Client	Hawthorn
Project	Portland, ME
Lead Designer	
Production Manager	Jason DiOrazio
Production Staff

Revision #	Sheet	Description of Change	A0.0 Dotted?	Assigned Date	Responsible Staff	Completion Date
6	A0.0	Added revision 6 to title block	Y			
	A0.1	Elevator Equipment room moved to rear of building. Wall type revised in Hall 148. Rear doors revised to storefronts.				
		Standpipe cabinet added in core. Standpipe note added to Legend.				
	A0.2	Tv room windows removed and revised. Standpipe cabinet added in core. Standpipe note added to Legend.				
	A0.3	Unit 323 revised. Standpipe cabinet added in core. Standpipe note added to Legend.				
	A0.4	Standpipe cabinet added in core. Standpipe note added to Legend.				
	A1.1	Carports added. Parking spaces revised.				
	A1.7	Dtl 1 removed.				
	A1.8	Dtl 5 added.				
	A1.9	Dtl 7 added. Zip system note added and zip added to details.				
	A2.1	Elevator Equipment room moved to rear of building. Wall type revised in Hall 148. Rear doors revised to storefronts.

DATE  
8/28/2015  
REVISED DATE  
SHEET  
**A8.9a**

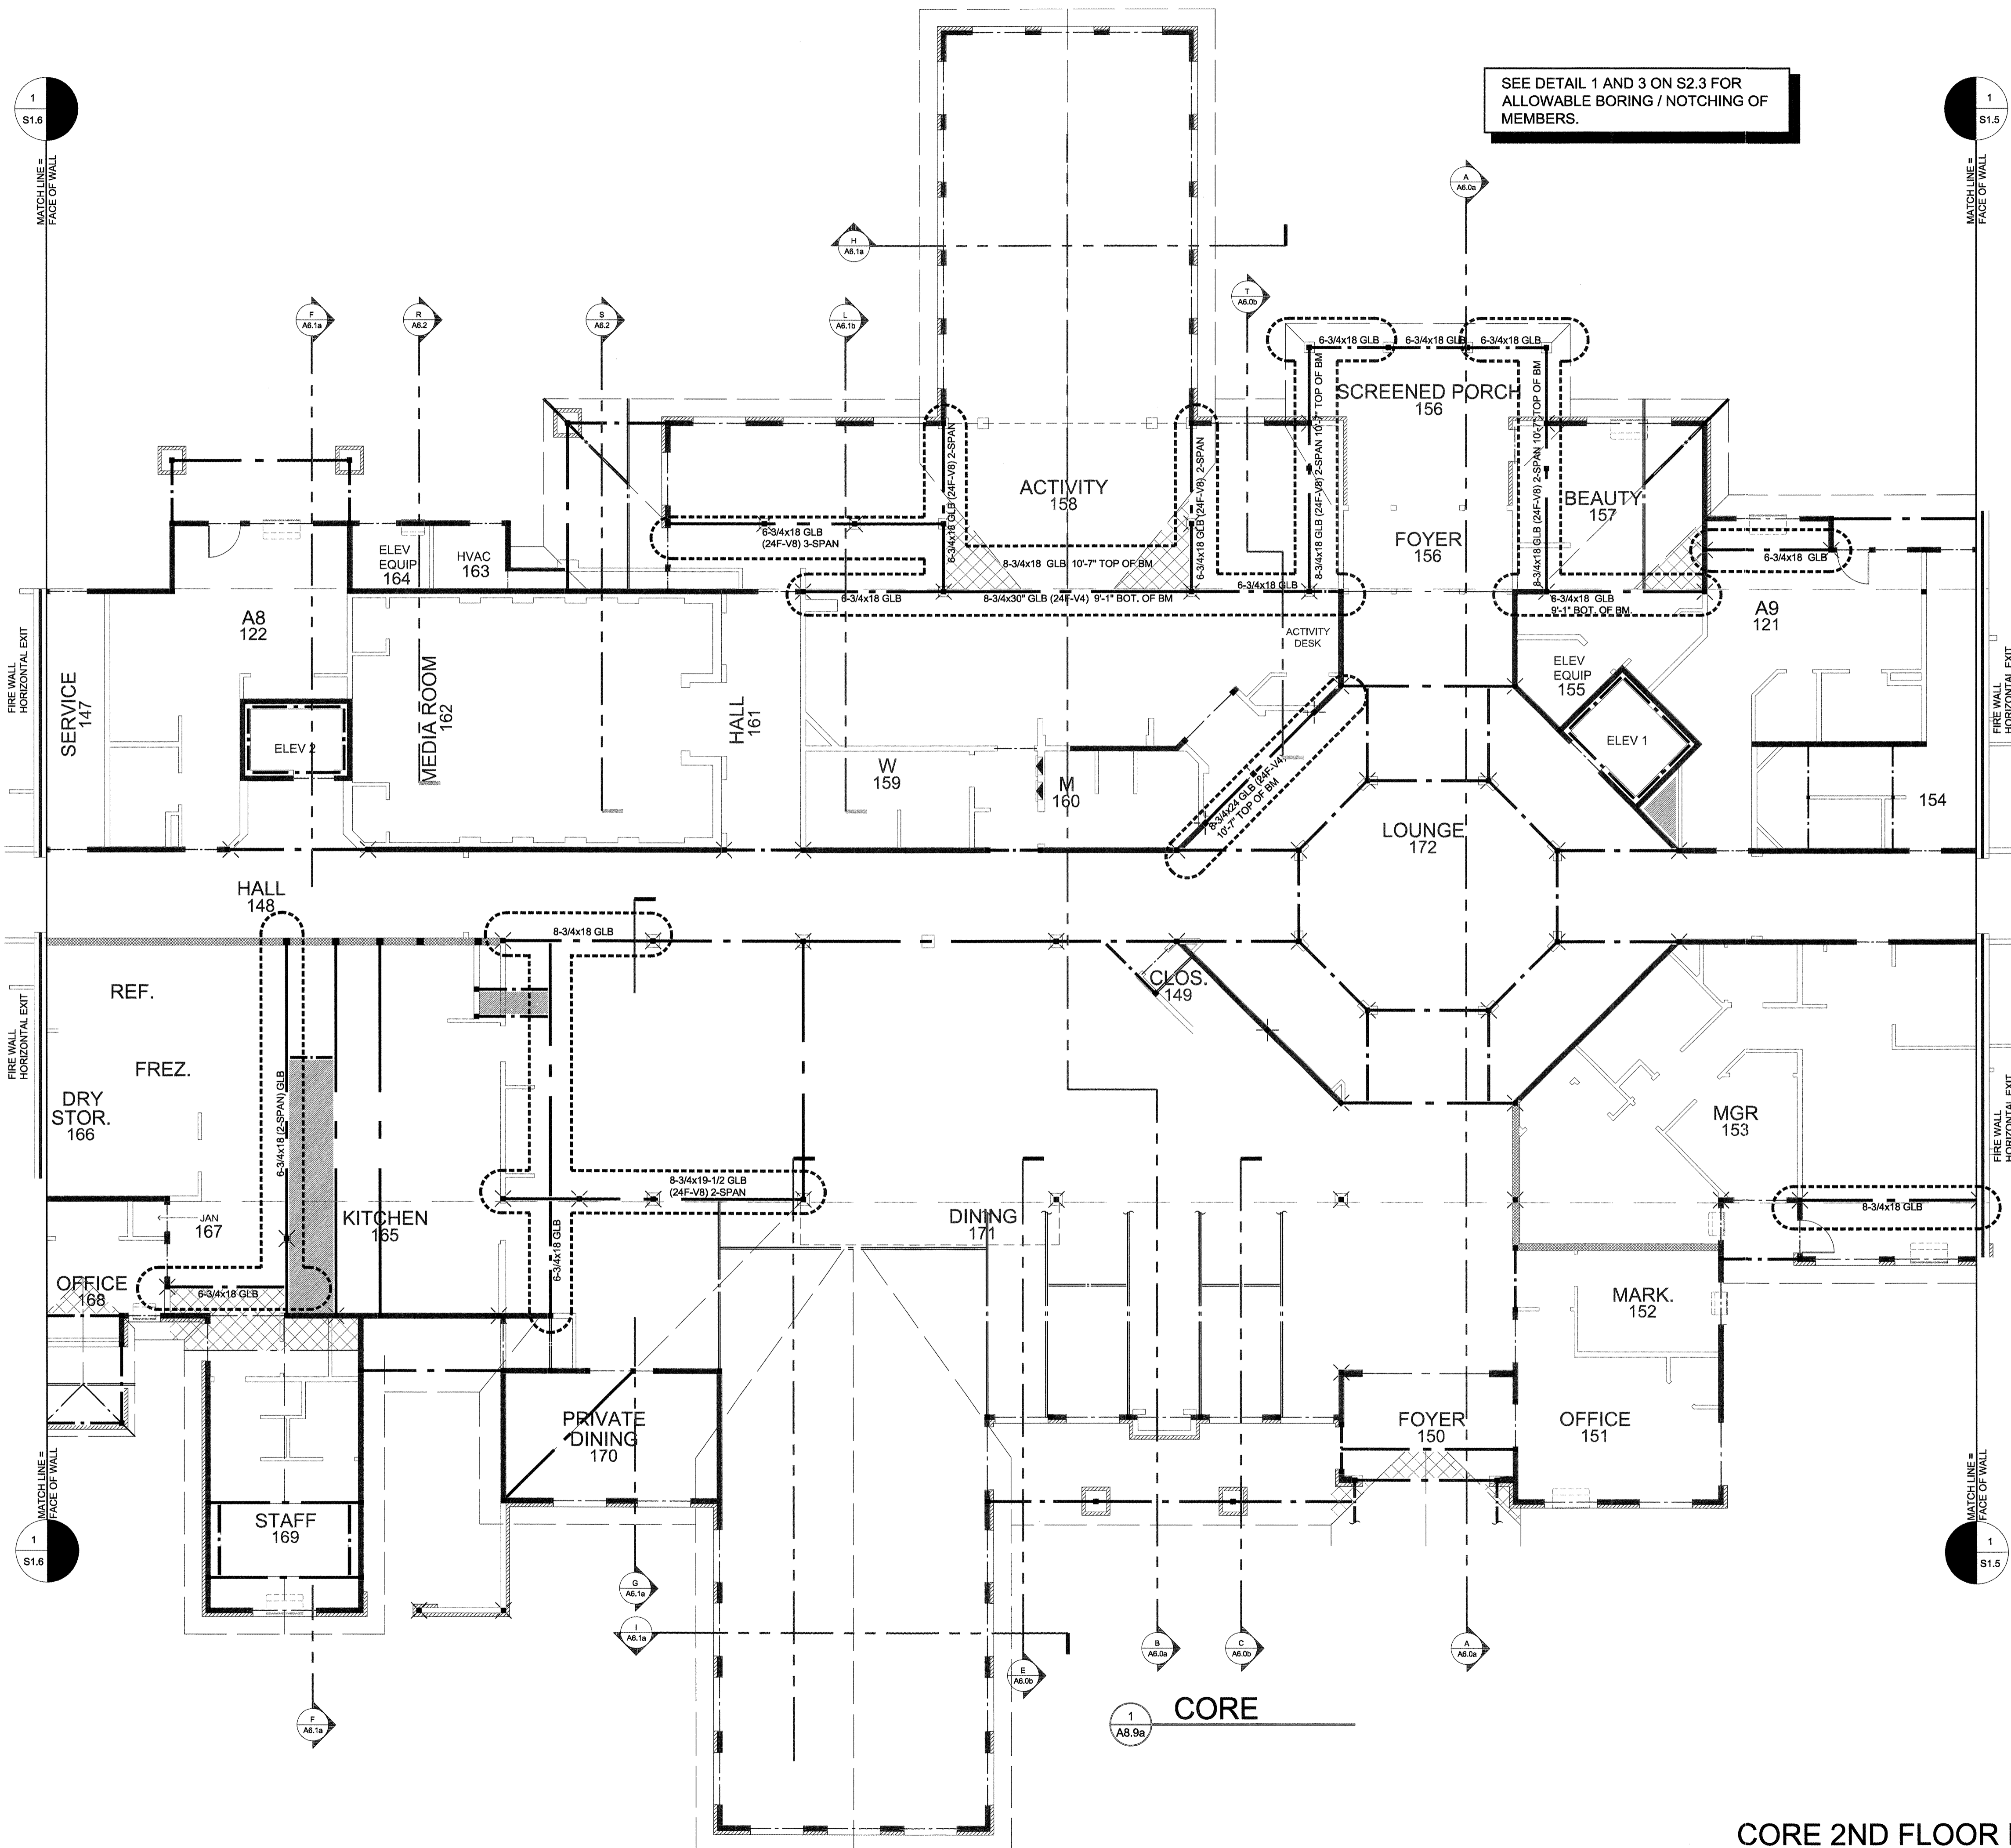
A8.4e	Under mount sink note added. Ceiling updated in dtl 1			
A8.5	Dtl 10 Note added.			
A8.6	Zip note added. Zip added to details 2, 15 and 16. Dtl 1 revised.			
A8.7	Zip note added. Zip added to detail 9.			
A8.8	Dtl 3 added.			
A8.9a	Elevator Equipment room moved to rear of building. Rear doors revised to storefronts. Beam at Office 168 revised.			
A8.9b	Tv room windows removed and revised.			
A8.9c	Sheet added.			
A8.9d	Sheet added.			
A8.9e	Sheet number changed.			
A9.0a	Tittle block revised. And Elevator updated.			
A9.0b	Tittle block revised. And Elevator updated.			
A9.1	Tittle block revised.			
S0.1	Holdowns revised.	Y		8/26/2016
S0.2	Shearwall revised.	Y		8/26/2016
S1.1	Columns revised at Kitchen and Dining room. Electrical Equipment room moved to rear. Footing at Hall 161 and Bistro revised. Rear Foyer doors revised.	Y		8/26/2016
S1.4	Framing at Dining and Private Dining revised. Kitchen and Office 168 trusses revised. Corridor walls revised. Girder trusses at Activity room updated	Y		8/26/2016

DATE  
 8/28/2015  
 REVISED DATE  
 9/22/2015  
**SHEET**  
**M3.5**

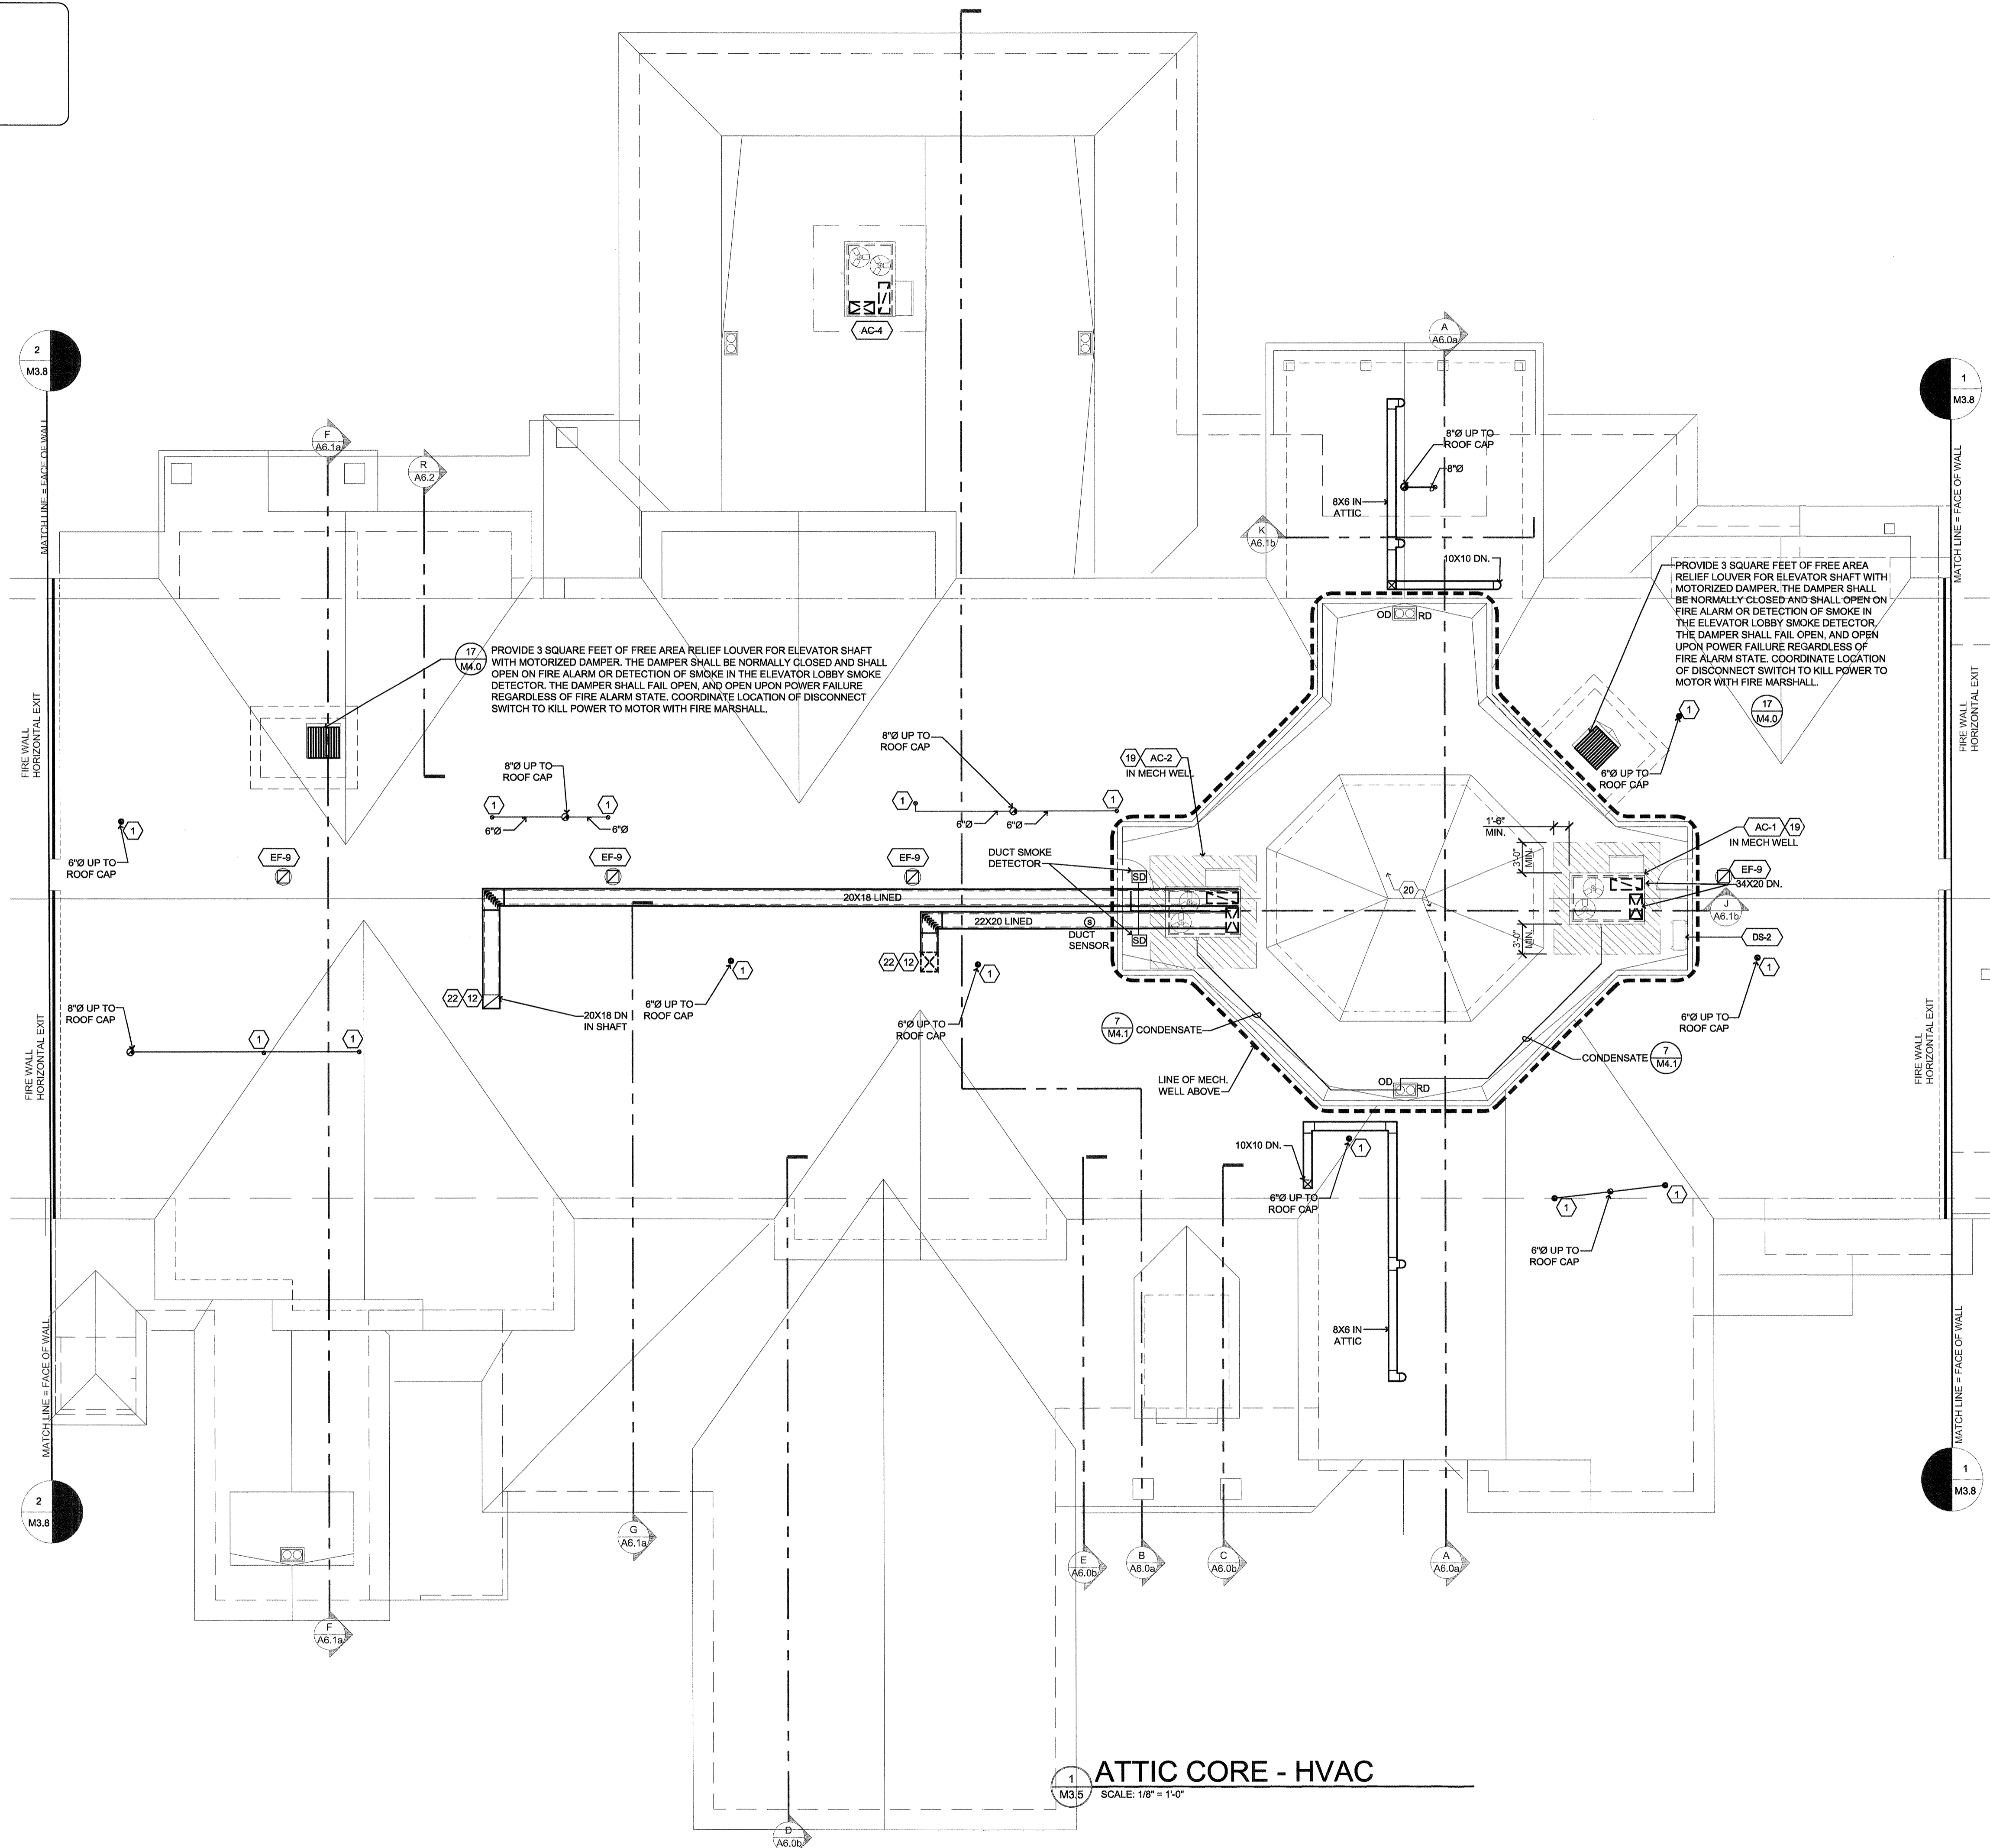
M3.4		Unit 401 CRD added. HVAC key note 31 added. PTAC note added.			
M3.5		Mech equipment above activity moved. Mech equipment added to roof.			
		HVAC key note 31 added. PTAC note added.			
M3.6		Louver added to Mech. Room. Laundry air transfer revised. Return duct added to all floors.			
		HVAC key note 31 added. PTAC note added.			
M3.7		Laundry air transfer revised. Return duct added to all floors.			
		HVAC key note 31 added. PTAC note added.			
M3.8		One exhaust duct removed.			
		HVAC key note 31 added. PTAC note added.			
M4.0		Dtl 5 added.			
M4.1		Dtl 12 removed.			
M4.2		HP-1 revised. EF-1a and EF-8a added. Dtls 1 and 2 revised.			
M4.6		Equipment revised.			
M5.1		Run Sprinkler pipe in soffit.			
M5.2		Section updated.			
E1.1L		Dimmers added. Rear Foyer door moved. Office 151 lighting revised.			
E1.2L		Dimmers added to Reading room.			
E1.7P		HP added to Mech. Well.			
E2.3b		Panel schedule revised. Gym HP-1 added.
